City of Albuquerque Stormwater Construction Site Inspection Report

Project Name and Location	advance auto parts 10126 Central SE		
Site Contact Name & Agency	Jerry Castillo Advance Auto parts	Contact Phone #/ E-mail	
Date of Inspection	4-4-17	Start/End Time	10:35/10:40
Inspector Name, COA Dept.	Curtis Cherne, Stormwater Quality		
Inspector Phone / E-mail	505-924-3420/ccherne@cabq.gov		
Inspector Qualifications	Qualified Compliance Inspector of Stormwater- Stormwater One		
Describe Present Phase of Construction	5/6th 1. 2nd

From: Cherne, Curtis
Sent: Friday, July 29, 2016 3:05 PM
To: castillofour@msn.com
Cc: 'grant@inspectionsplusinc.com'
Subject: Advanced Auto Parts SWPPP inspection
Attachments: sediment_central.jpg; west_edge.jpg; south_edge.jpg; central_no_BMP.jpg

TEMPORARY EROSION AND
SEDIMENT CONTROL
MEASURES PLAN

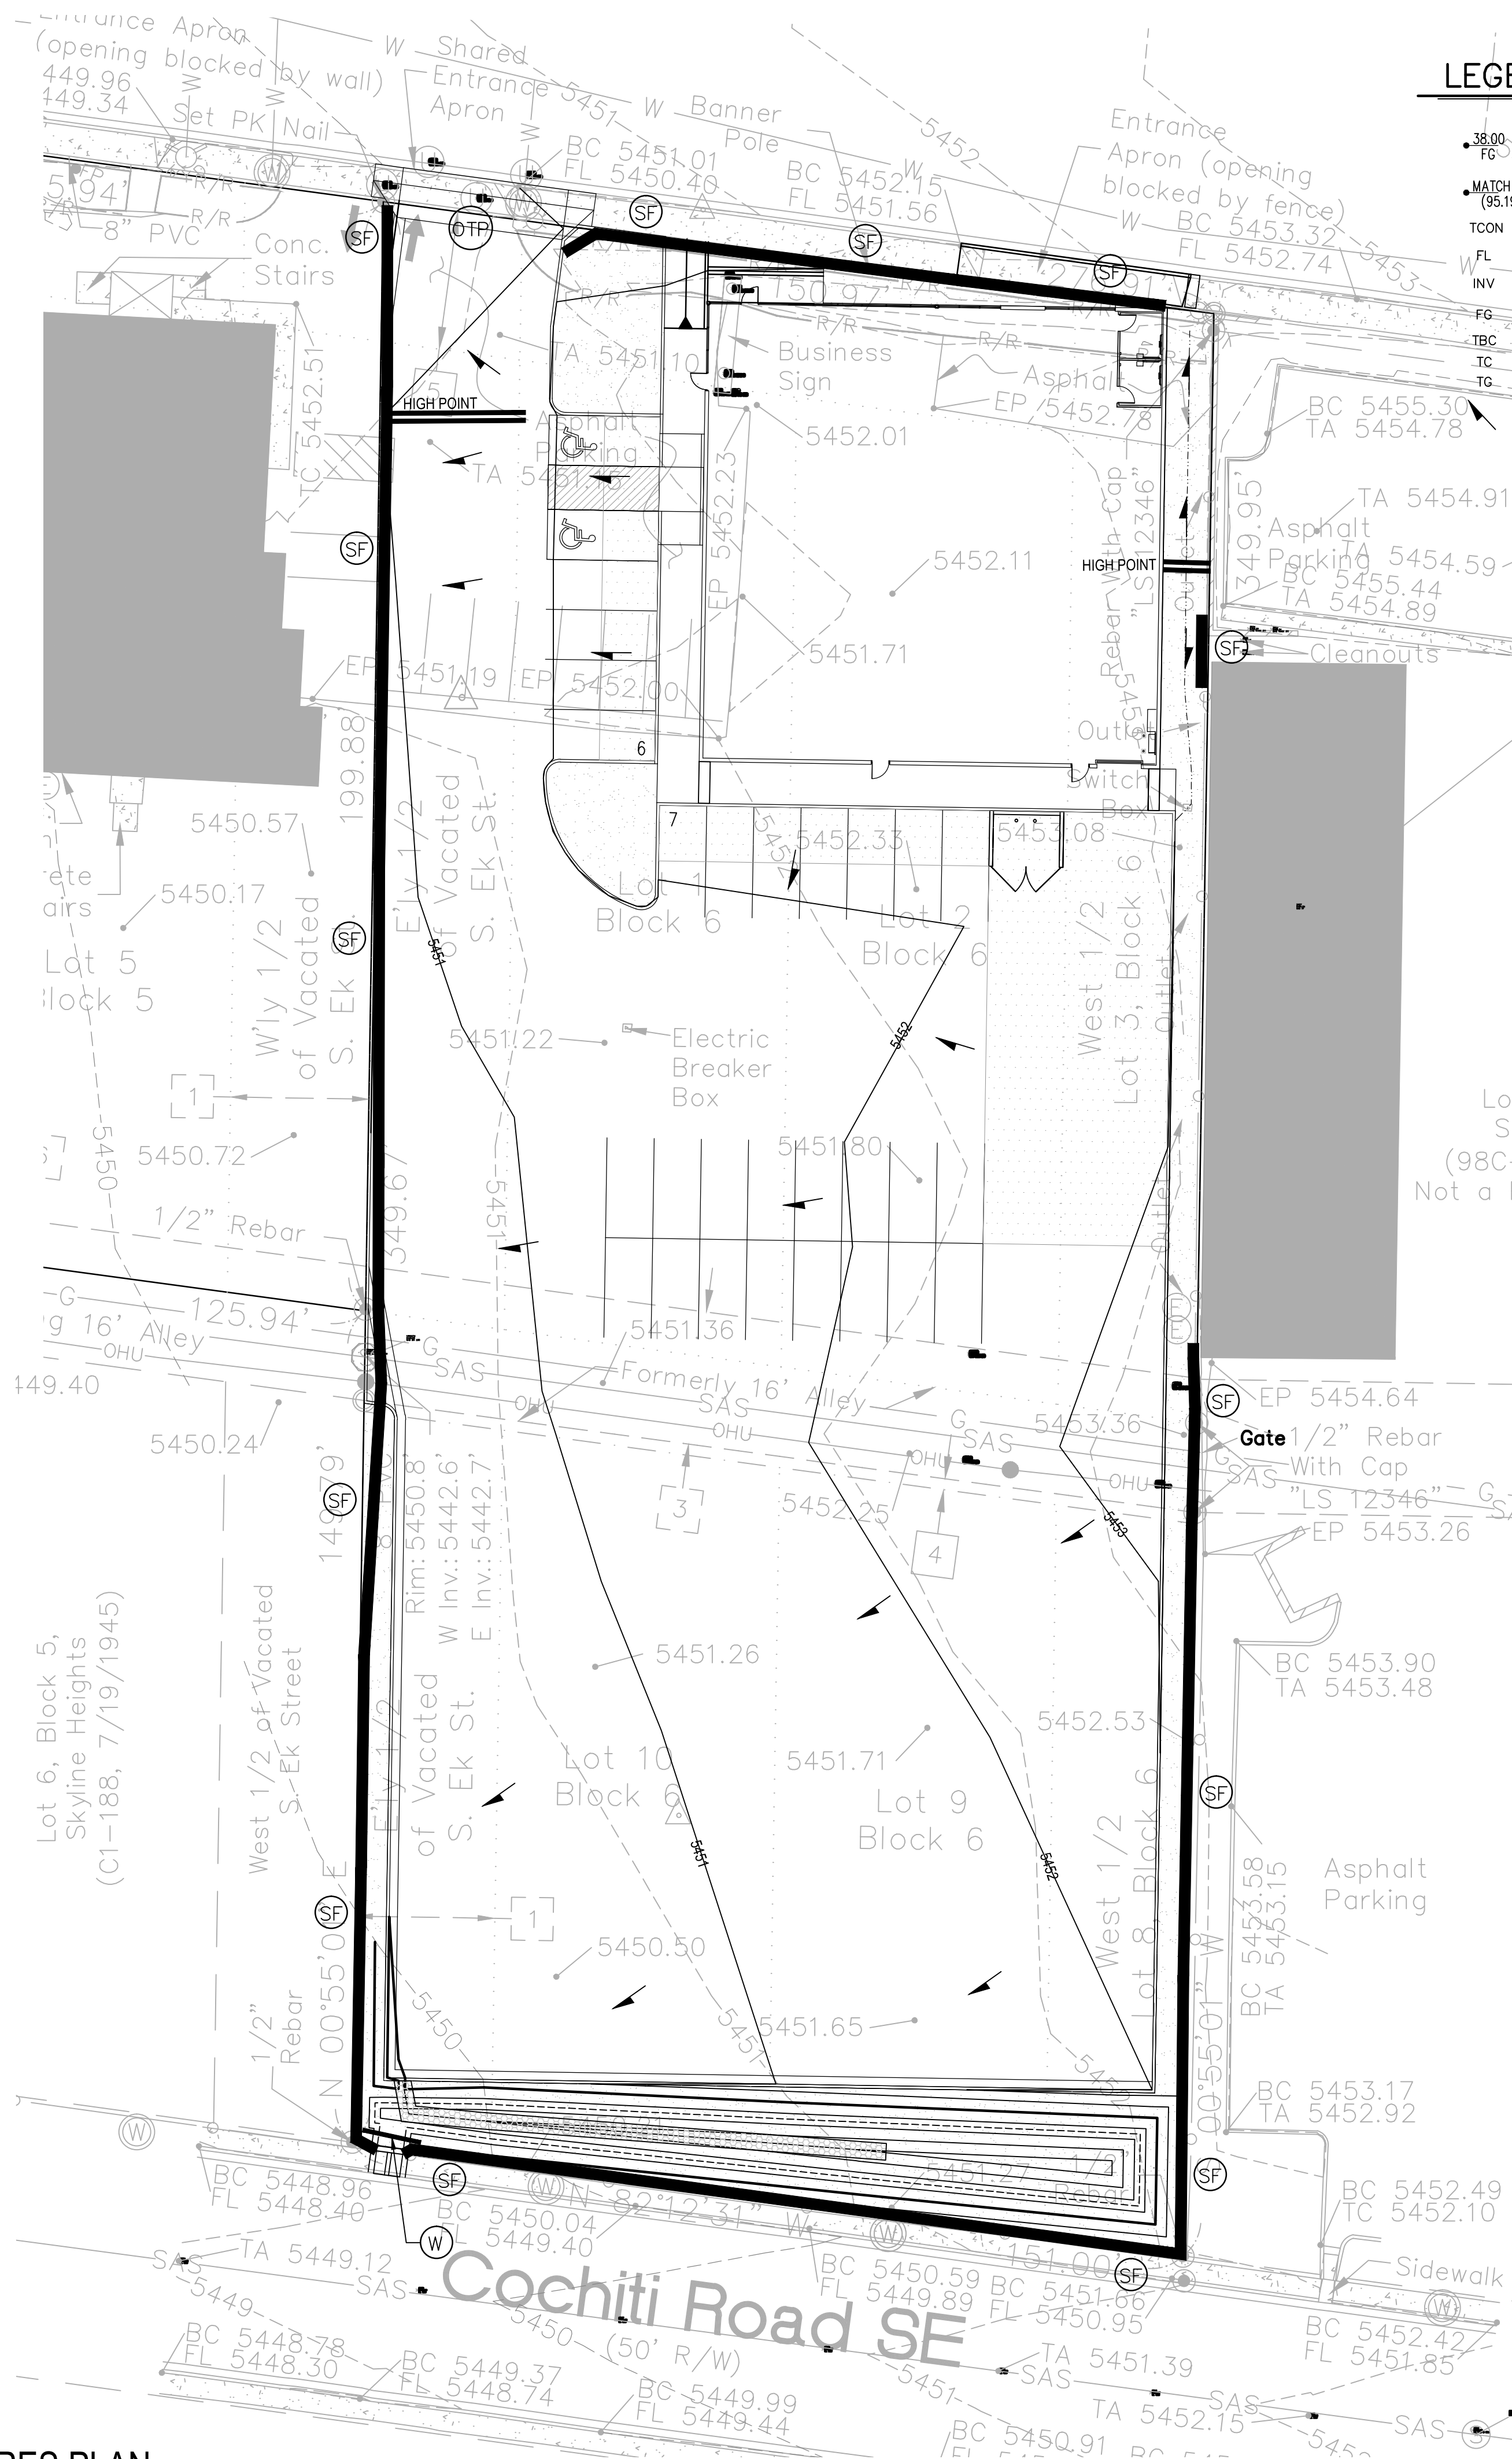
Not sure if the project boundaries changed. The ESC plan I have shows the project boundary and silt fence along Cochiti Rd, but there is a construction fence with silt fence midway between central and Cochiti?

1. There is no silt fence along Central, except in the northwest corner and there is a considerable amount of dirt on the sidewalk. The silt fence should be placed at the back of sidewalk. Not sure if you will hear about the construction fence taking up part of the sidewalk. The dirt is to be removed from the sidewalk and silt fence or other sediment BMP installed.
2. The ESC plan calls for silt fence along the west edge of the project. There was some at the northwest and southwest corners.
3. The sub was there that will pour the foundation. He anticipates next Tuesday. There was no concrete wash-out area on site. A bin or lined pit should be onsite when doing concrete, mortar or stucco work.

There was not a usual track-out pad. There may be enough distance from the street to the current entrance to minimize track-out onto Central Ave.

The plan for Advanced Auto did change. It shrunk as you noticed. We went out and installed silt fence. The stretch without silt fence along central had asphalt that had to be removed. We will be back there on Monday to close the gap.
Thank
